RE: SSD-25452459 FIRST BUILDING BRADFIELD CITY CENTRE SSDA RESPONSE TO SUBMISSIONS ON TRAFFIC

Introduction

Table 1 Response to submissions on traffic and Transport

TURNING PATH PLAN -  
12.5m HRV

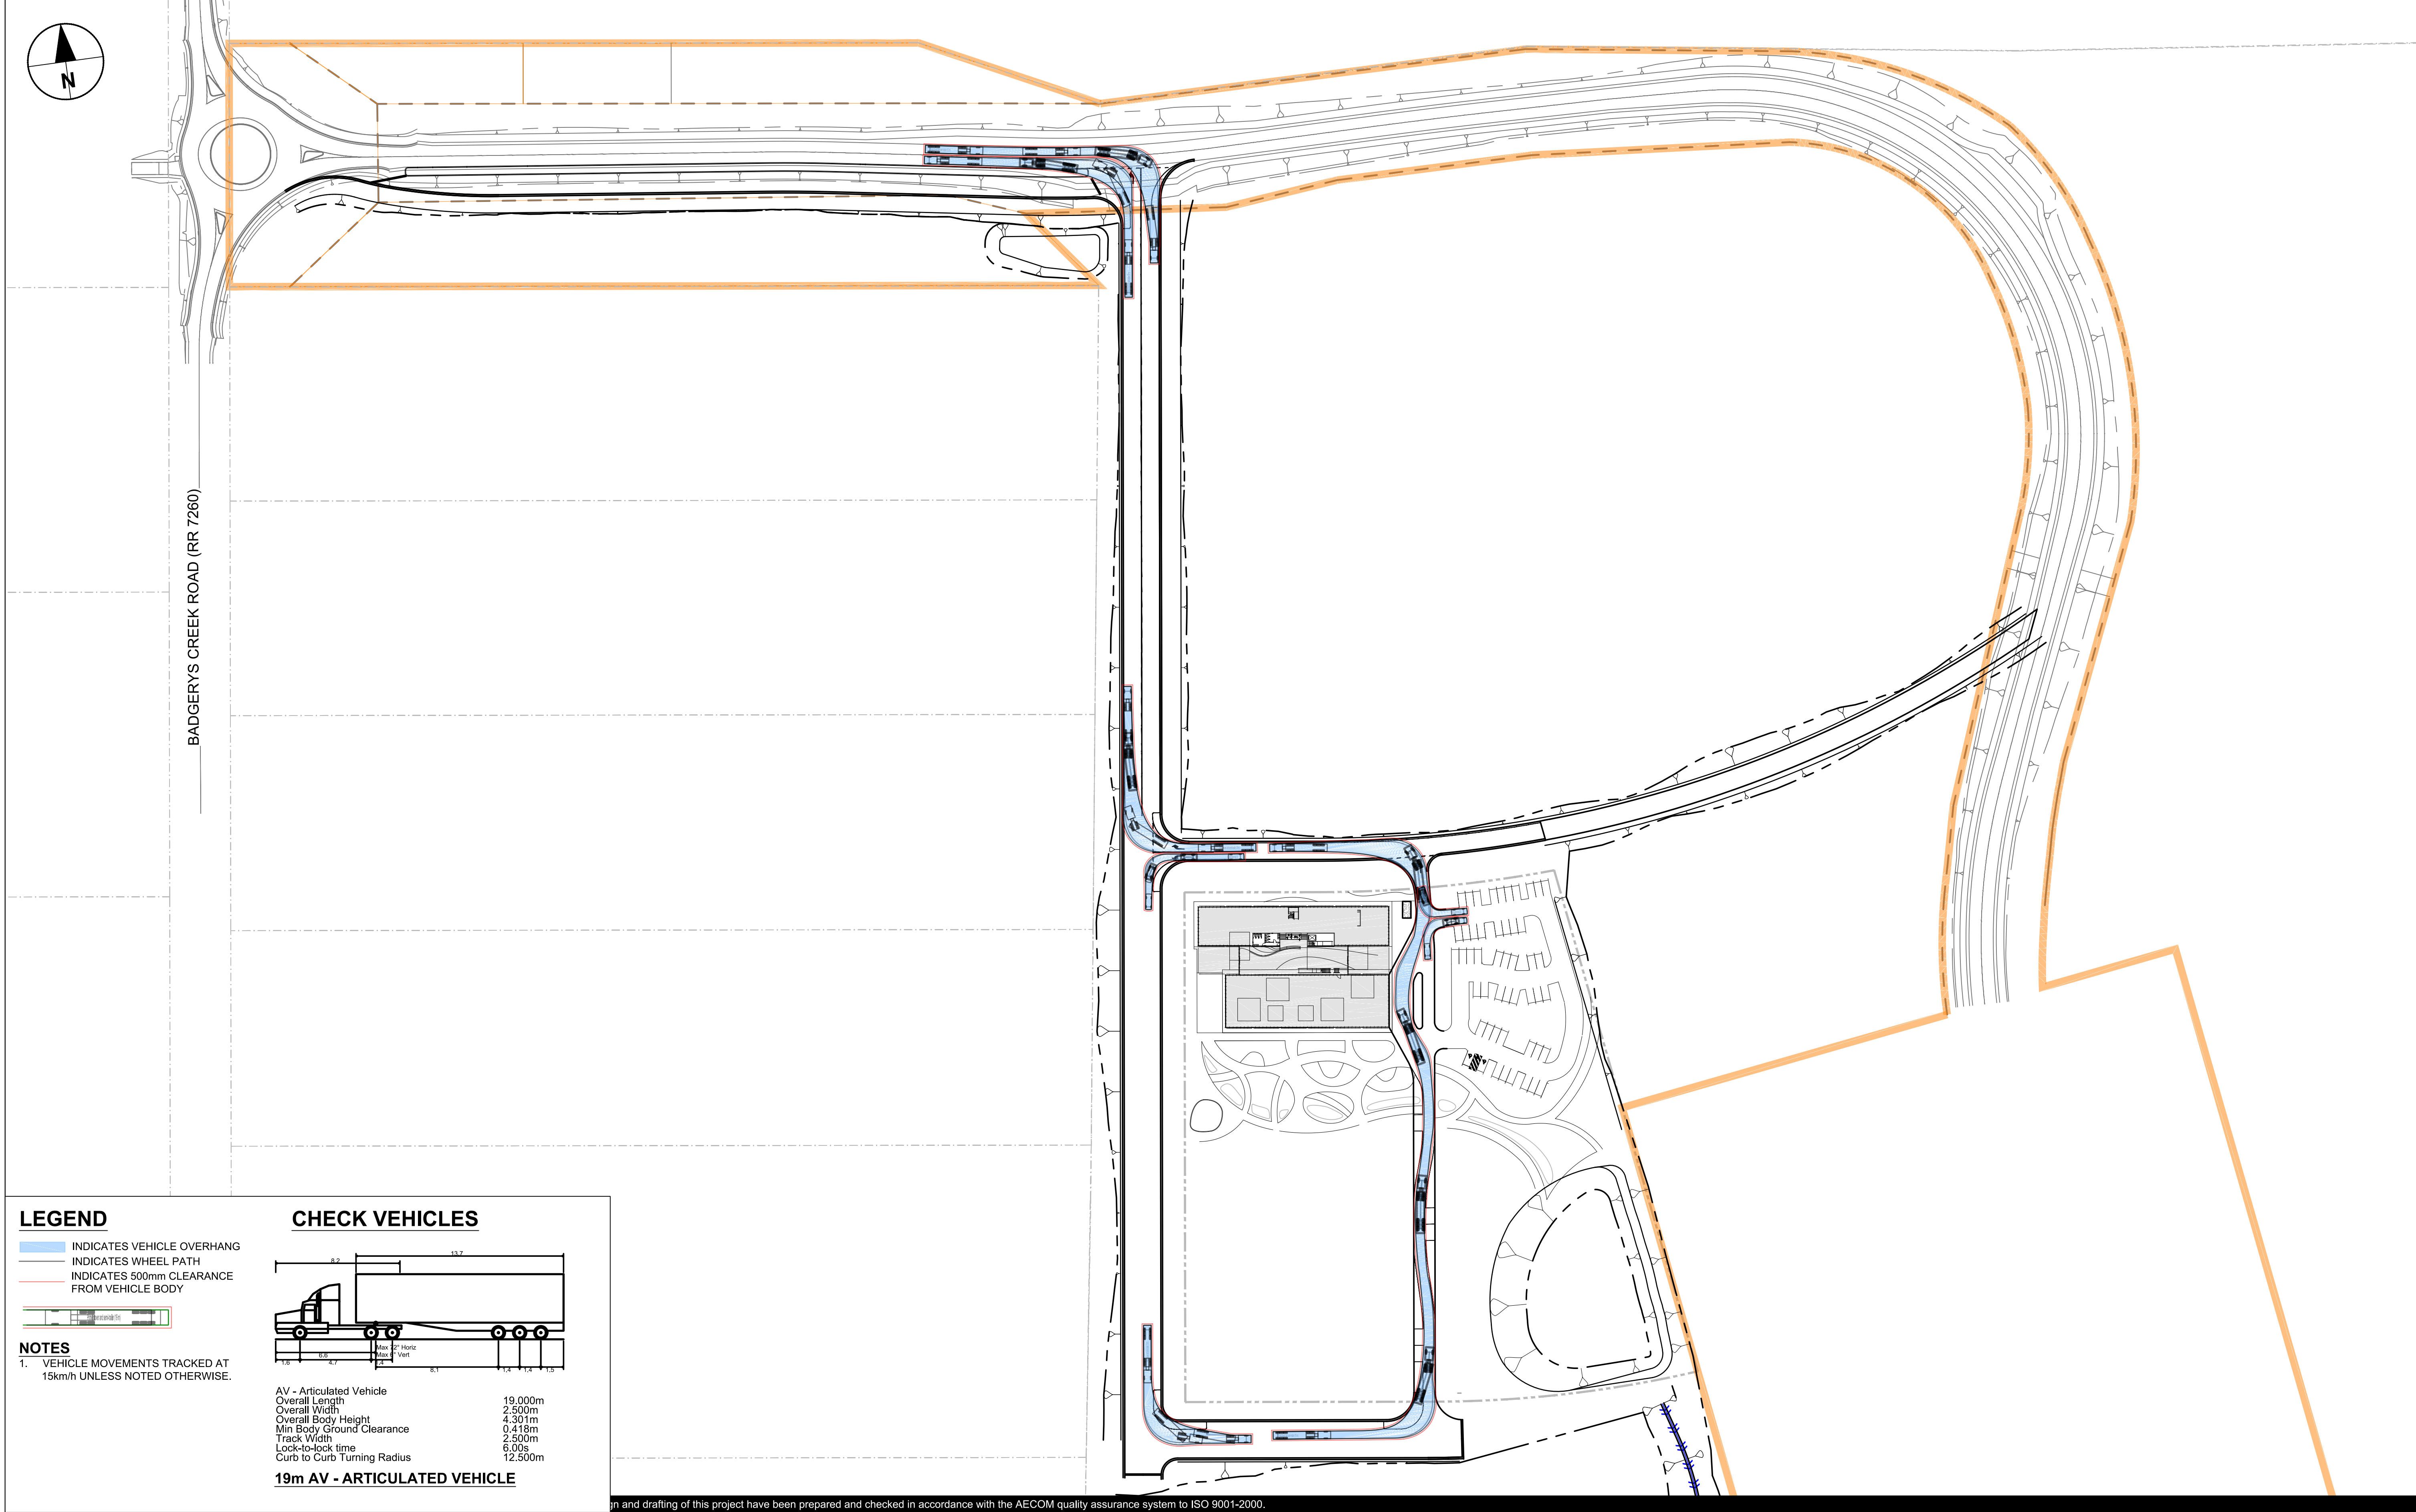
6B	The civil plans include swept path diagrams of the largest truck accessing the site along the service road. Where is the designated heavy vehicle parking on the service road and how are heavy vehicles load and unloaded? Can heavy vehicles reverse in to the loading bay?	A porte-cochere is proposed at the ground level to facilitate loading activities. The porte-cochere is adjacent to the north-south vehicle access link and allows service vehicles or waste trucks to access the loading zone without reversing. The designated loading zone is separated from the general travel lane by a median, which allows other vehicles to traverse through the site while a heavy vehicle is parked. The swept path diagrams show that the largest truck (19m AV) can access the port cochere for loading and unloading activities.
